27<sup>th</sup> of February 2019

Our Ref: 176862

**RE: Development Application – Doncaster Avenue Student Accommodation (SSD 9649)**

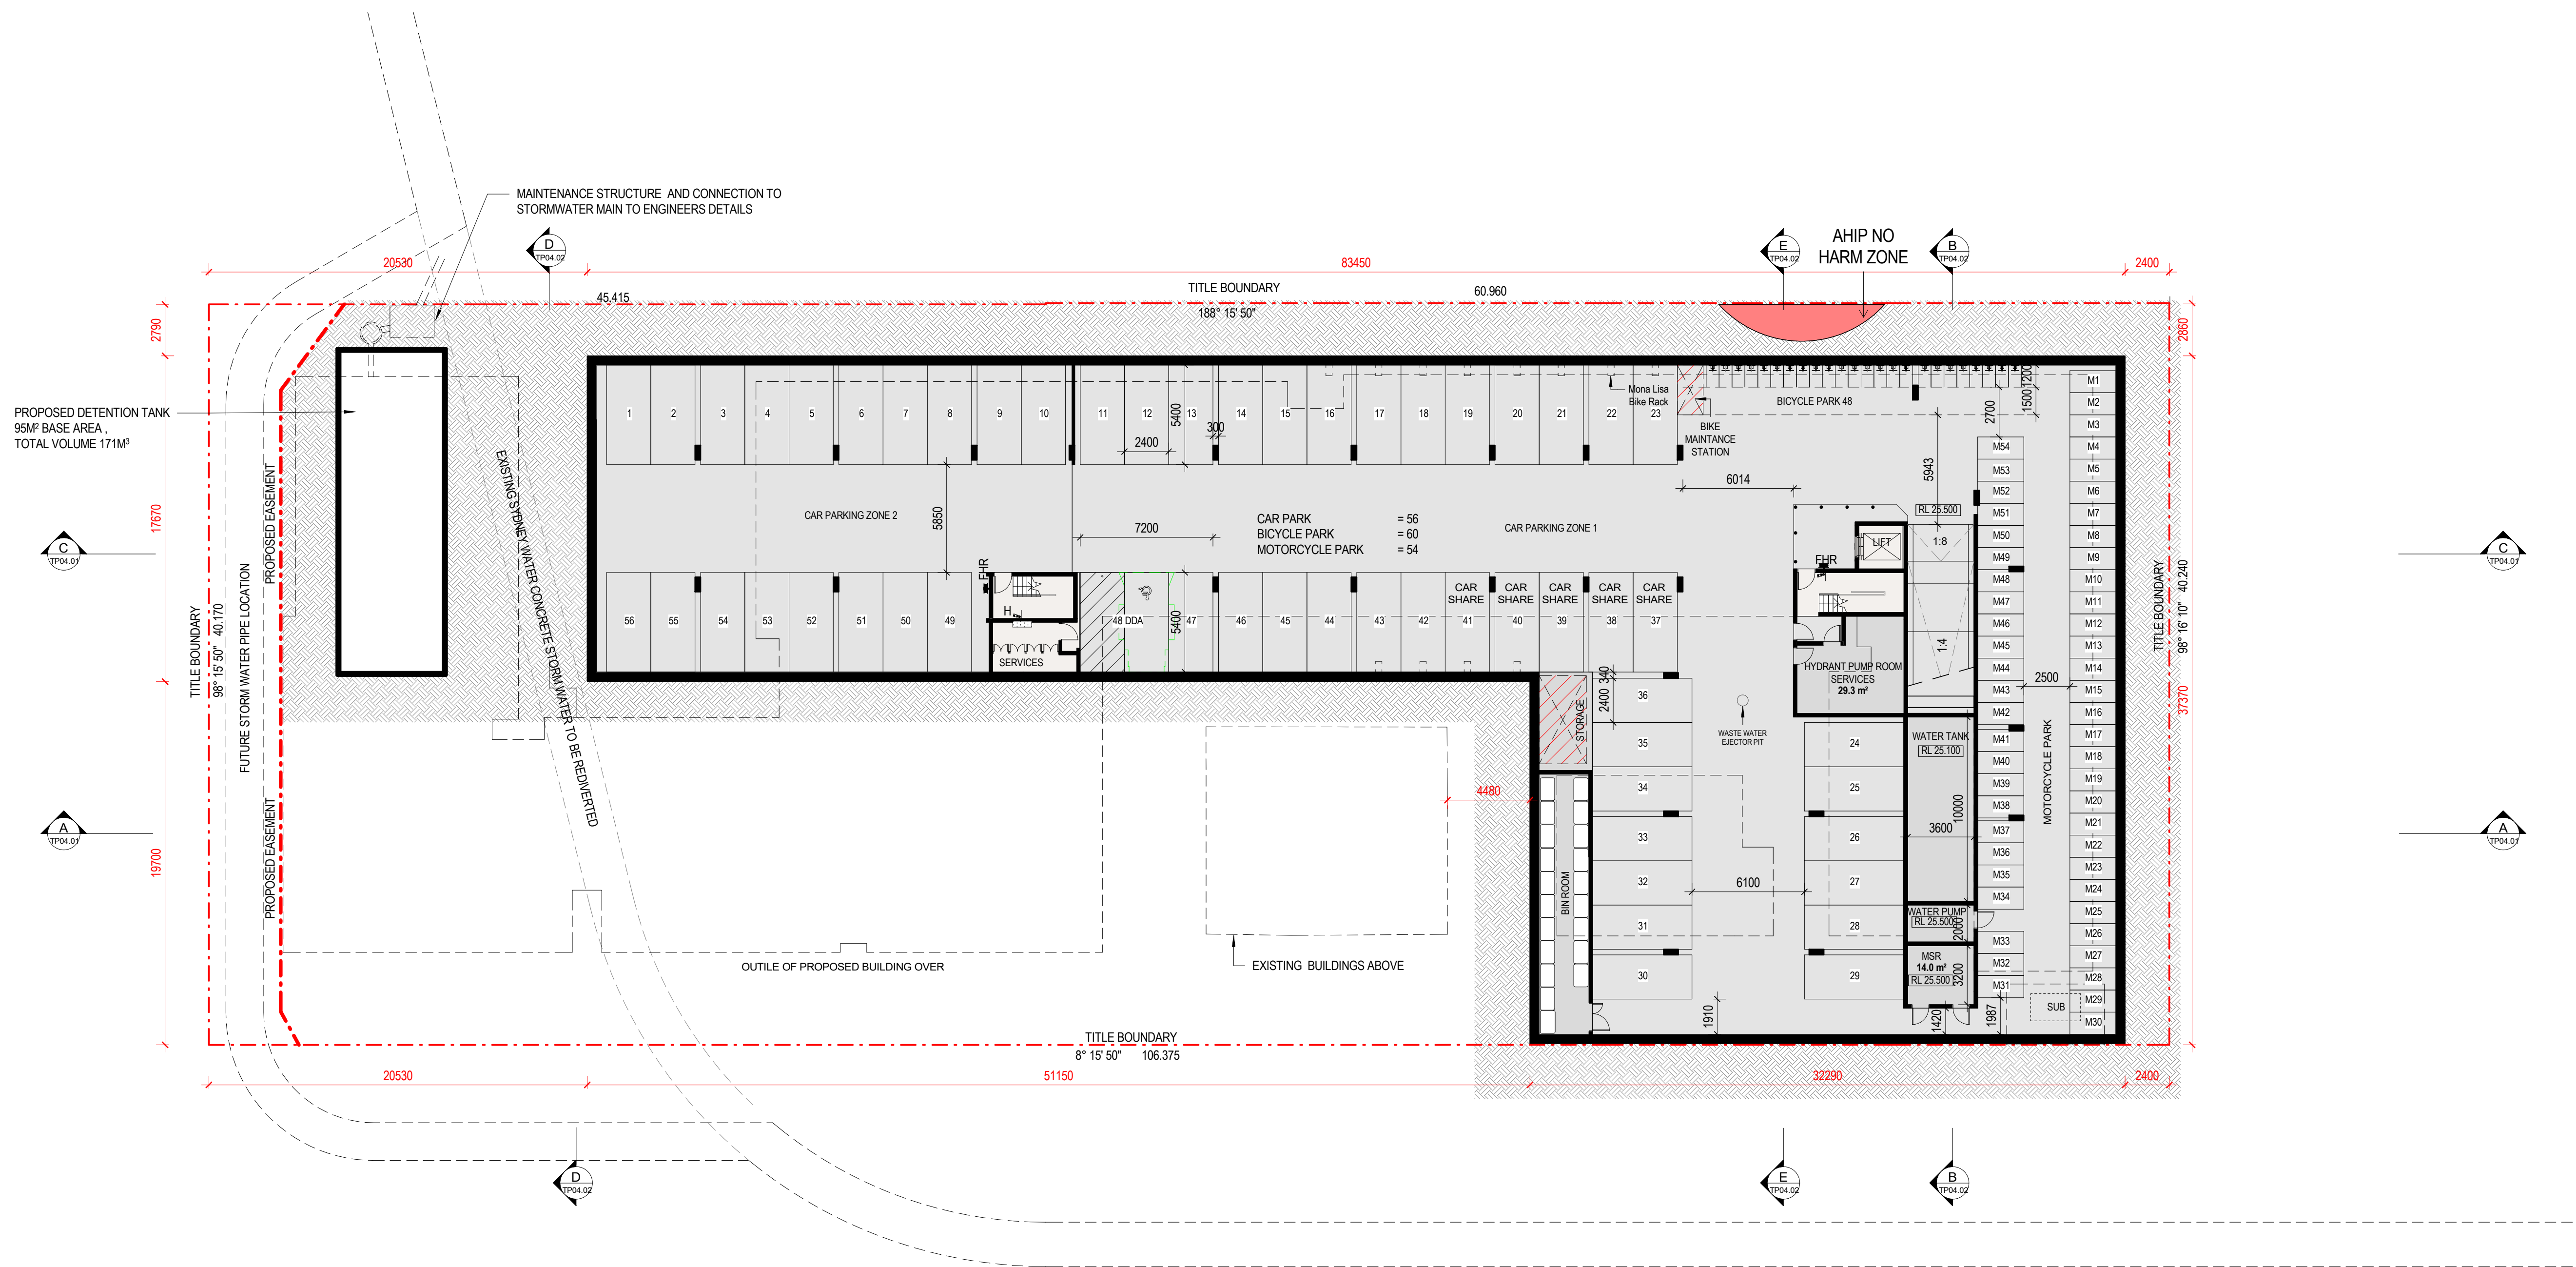
- No buildings or permanent structures are to be proposed over or within **1m** from the outside wall of the stormwater asset. Permanent structures include (but are not limited to) basement car park, hanging balcony, roof eaves, hanging stairs, stormwater pits, stormwater pipes or similar structures. This clearance requirement would apply for unlimited depth and height.

- Sydney Water has noted from the drawing no "2309 TP02.01 Rev 1 Dated 19/12/2018" titled "Basement Plan" that the proponent has the intention to deviate the Sydney Water's stormwater channel to address Sydney Water's requirements. Even though this concept of deviating the stormwater channel was discussed two years ago, it has not been progressed to the extent that the Sydney Water can accept this deviation proposal.

- In the meantime, Light Rail Stabling Yards, which is located on the western side of the proposed development site has deviated the existing Sydney Water's stormwater channel in the recent past and Sydney Water is yet to receive the Work As Constructed drawings. Based on this deviated stormwater channel in the Light Rail Stabling Yards, the current concept drawing for stormwater deviation need to be refined to achieve better hydraulic efficiency.

- Proponent is required to liaise with Sydney Water to reach an acceptable stormwater deviation proposal and to progress the design to an extent, that any proposed deviation of Sydney Water's stormwater channel is practically possible. Sydney Water's concurrence to the current proposal is subject to the proponent meet the above requirements.
